**CHENNAI METROPOLITAN DEVELOPMENT AUTHORITY**  
Thalamuthu Natarajan Building, No.1, Gandhi Irwin Road, Egmore,  
Chennai - 600 008  
Phone : 28414855 Fax: 91-044-28548416  
E-mail: mscmda@tn.gov.in  
Web site: www.cmdachennai.gov.in

**(Development Charges Letter)**

File No. : **CMDA/PP/NHRB/S/0403/2022**

Sub: CMDA – Area Plans Unit - ‘B’ Channel (South) - The Planning Permission Application is for the proposed construction of Stilt Floor + 3 Floors (14.0m height) Office use (Commercial) cum single Dwelling unit at First and Second floor Part at Plot No.164, Defence Officers Colony 13th Cross Street, Nandambakkam, Chennai – 600 062 Comprised in Old S.No.163, New S.No. 163/35 of Nandambakkam Village Within the Limits of Greater Chennai Corporation – Remittance of DC & Other charges – DC advice Sent – Reg.

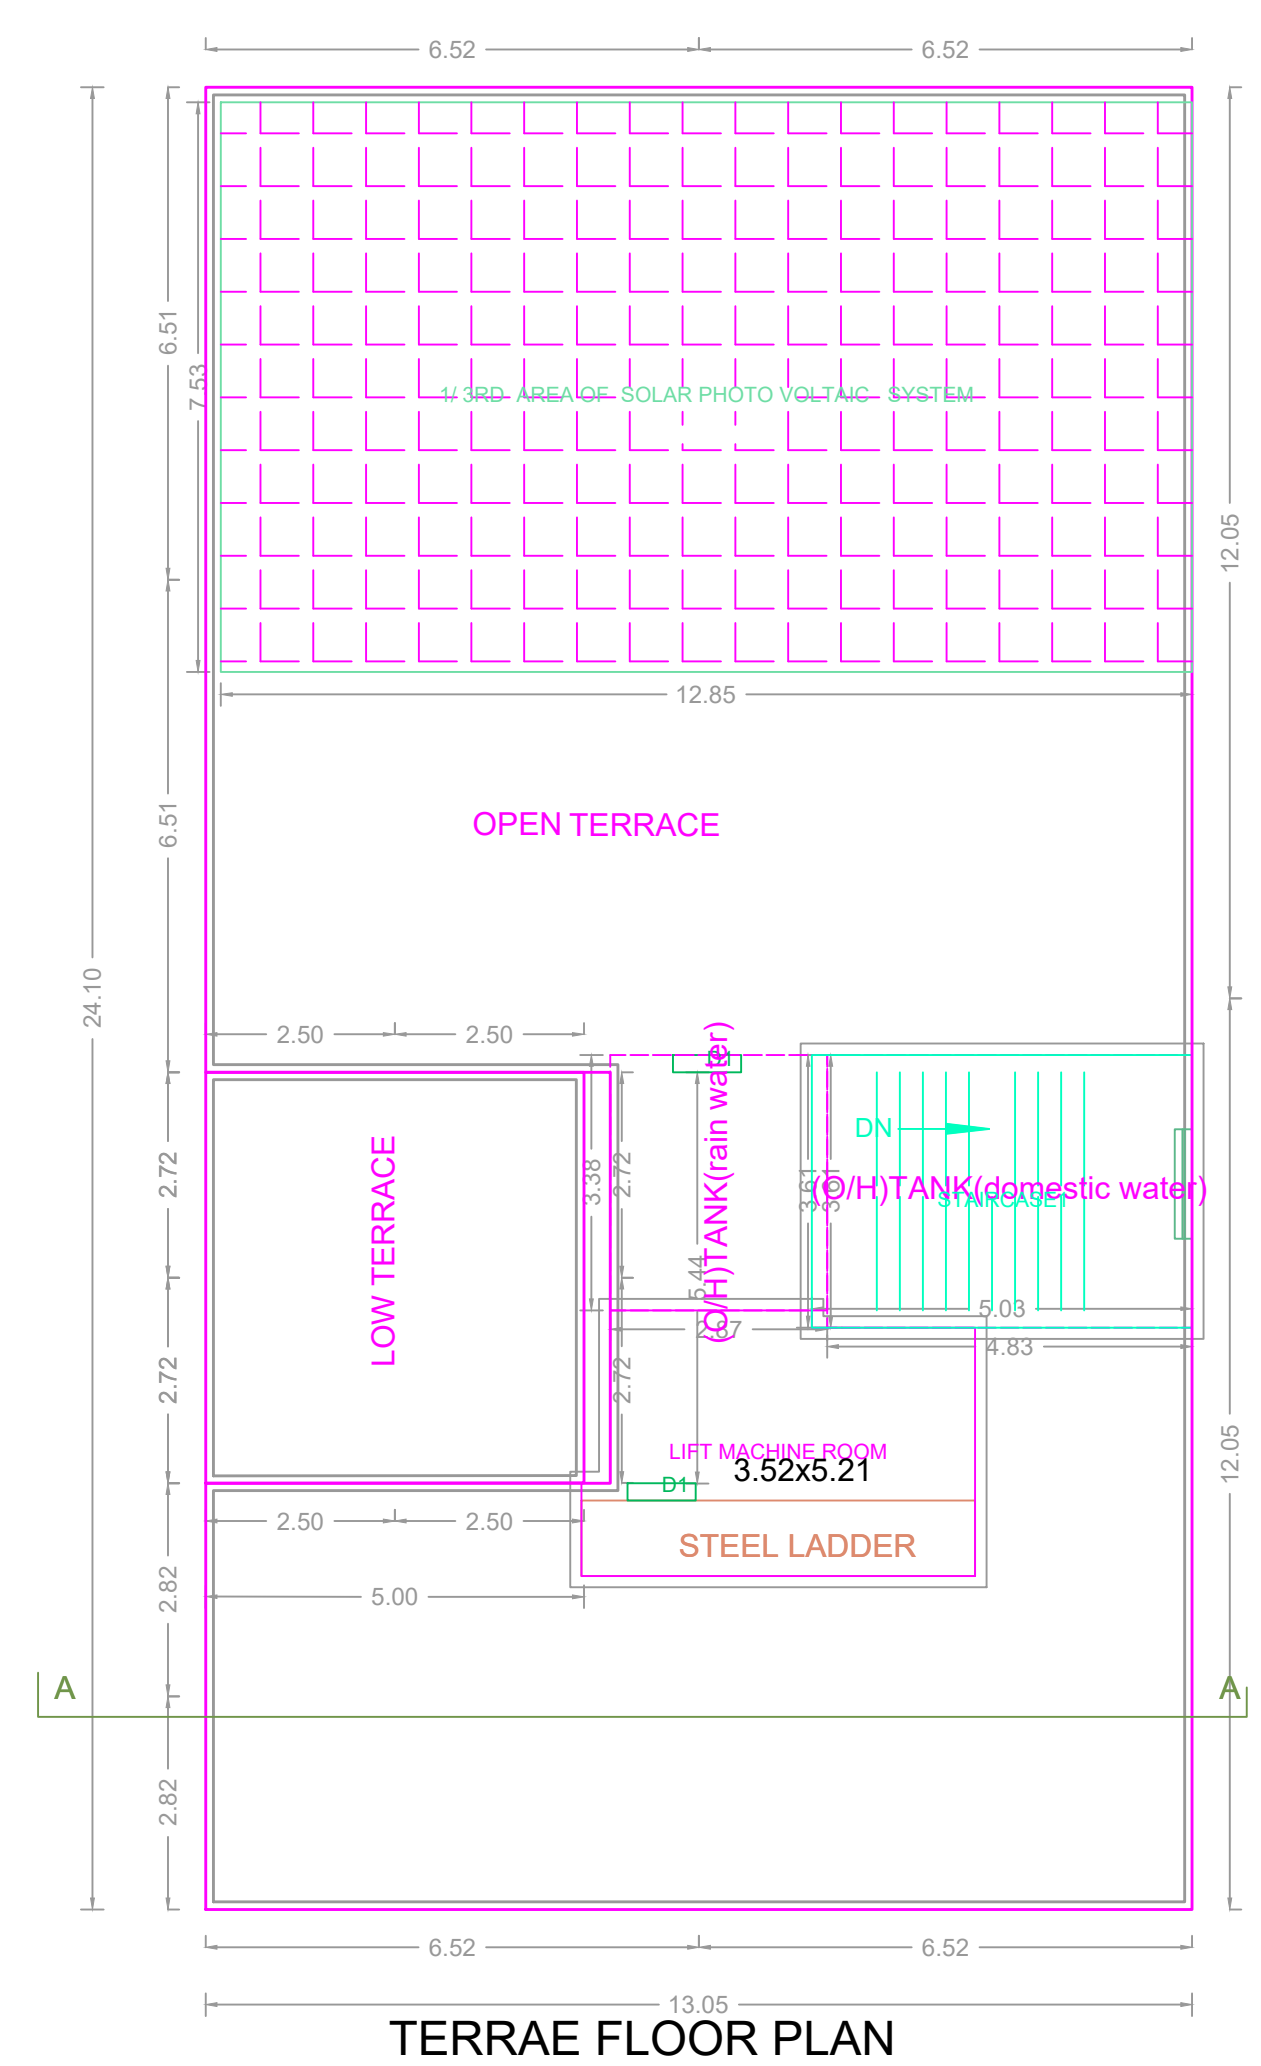
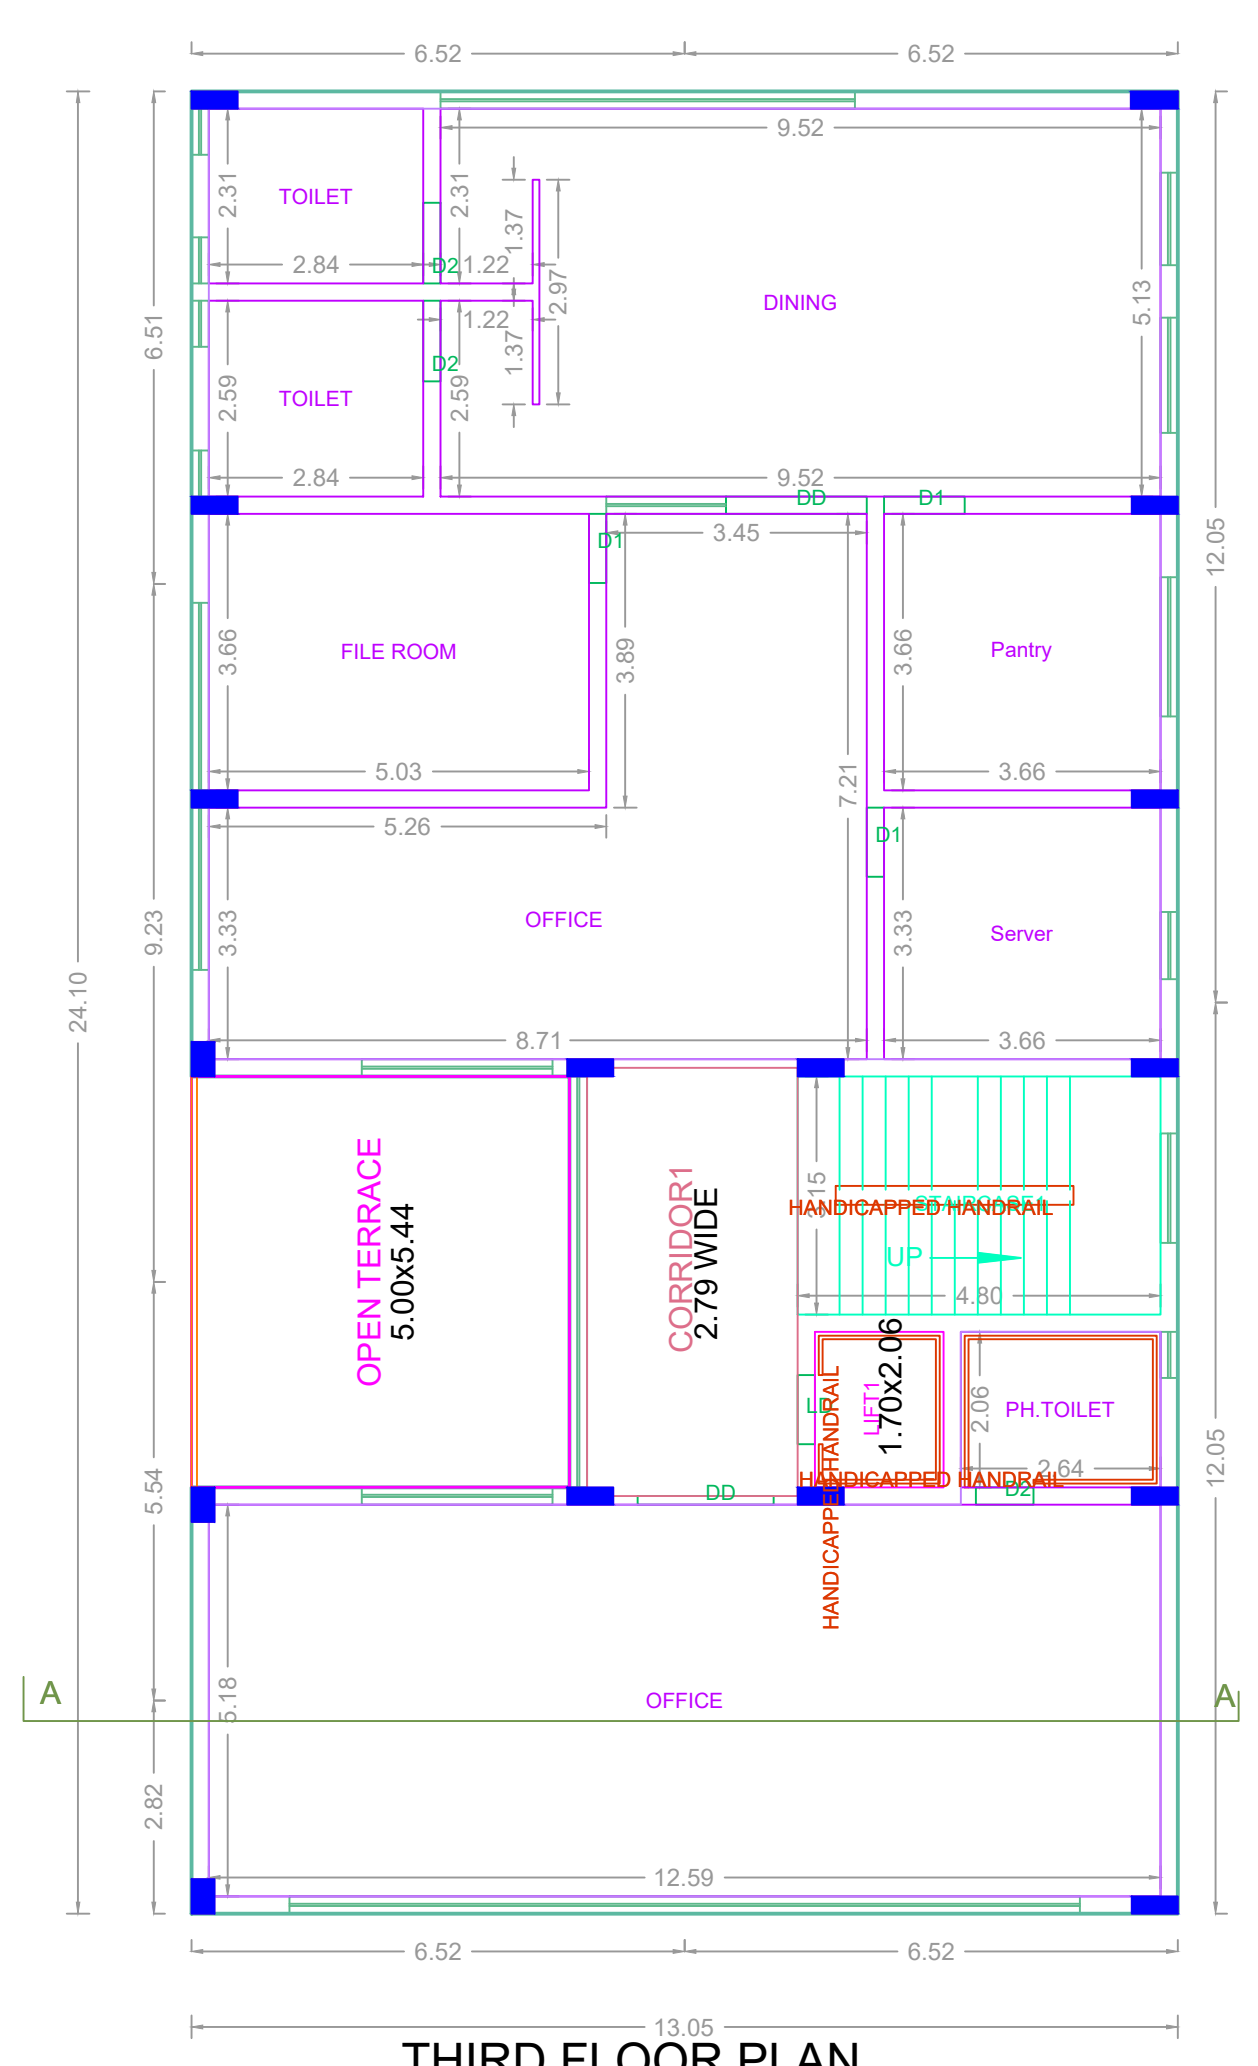
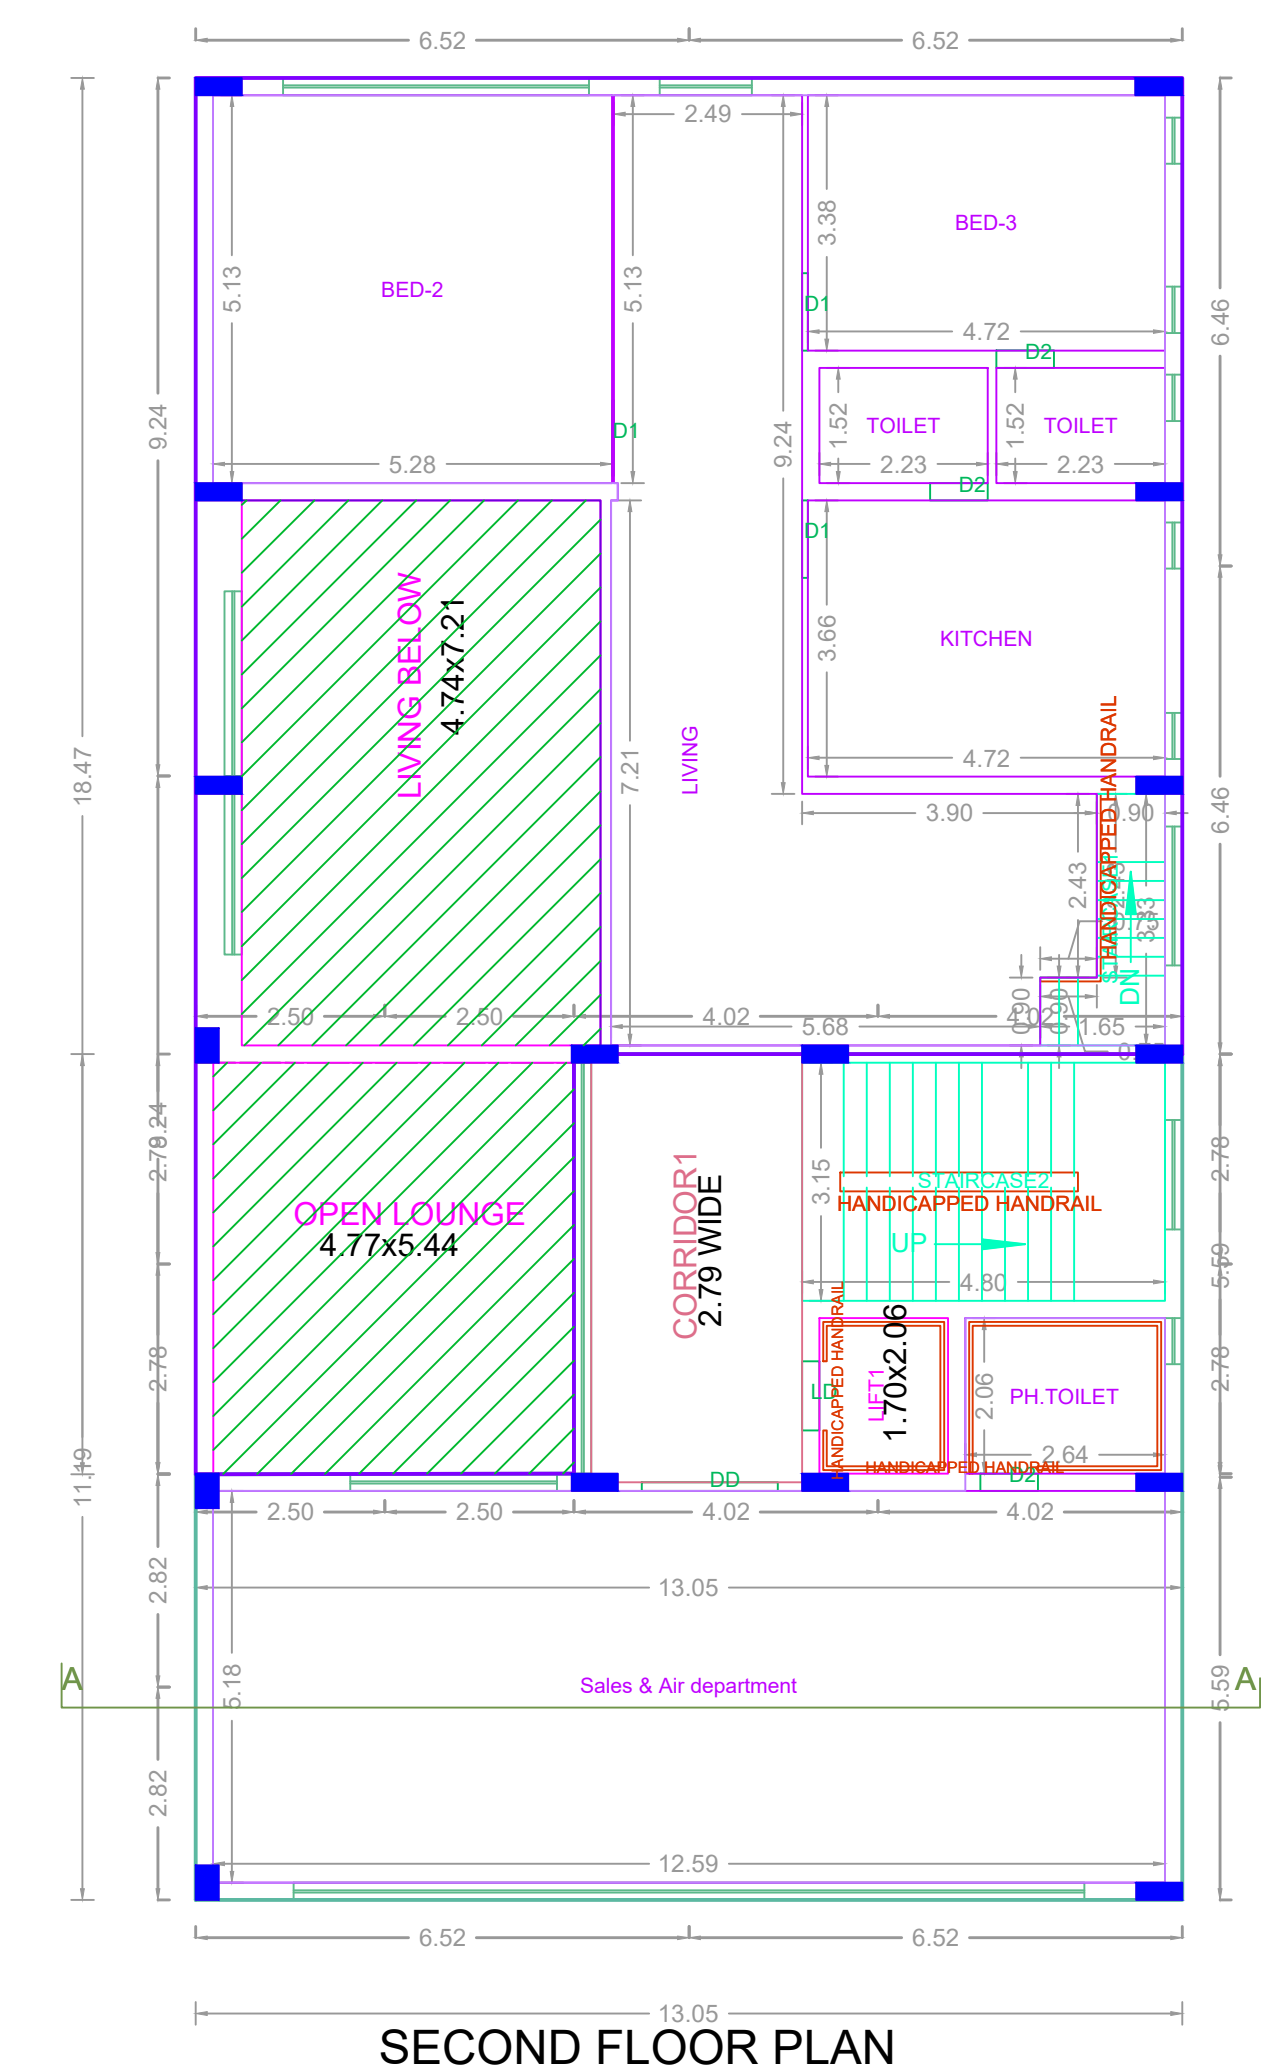
1. Office area in first and Second floor plan to be clearly named/shown as "Office"
2. The Open space shown next to Open lounge in Second floor plan to be included in FSI area
3. Second floor residential unit Staircase to be shown correctly in Second floor plan
4. In Terrace floor plan: Low Terrace to be correctly shown as "Low Terrace at Second Floor"
5. Parking Statement to be corrected (Car Parking: Required-9Nos, Available-9Nos; Tw parking: Required-17Nos, Available-29Nos)
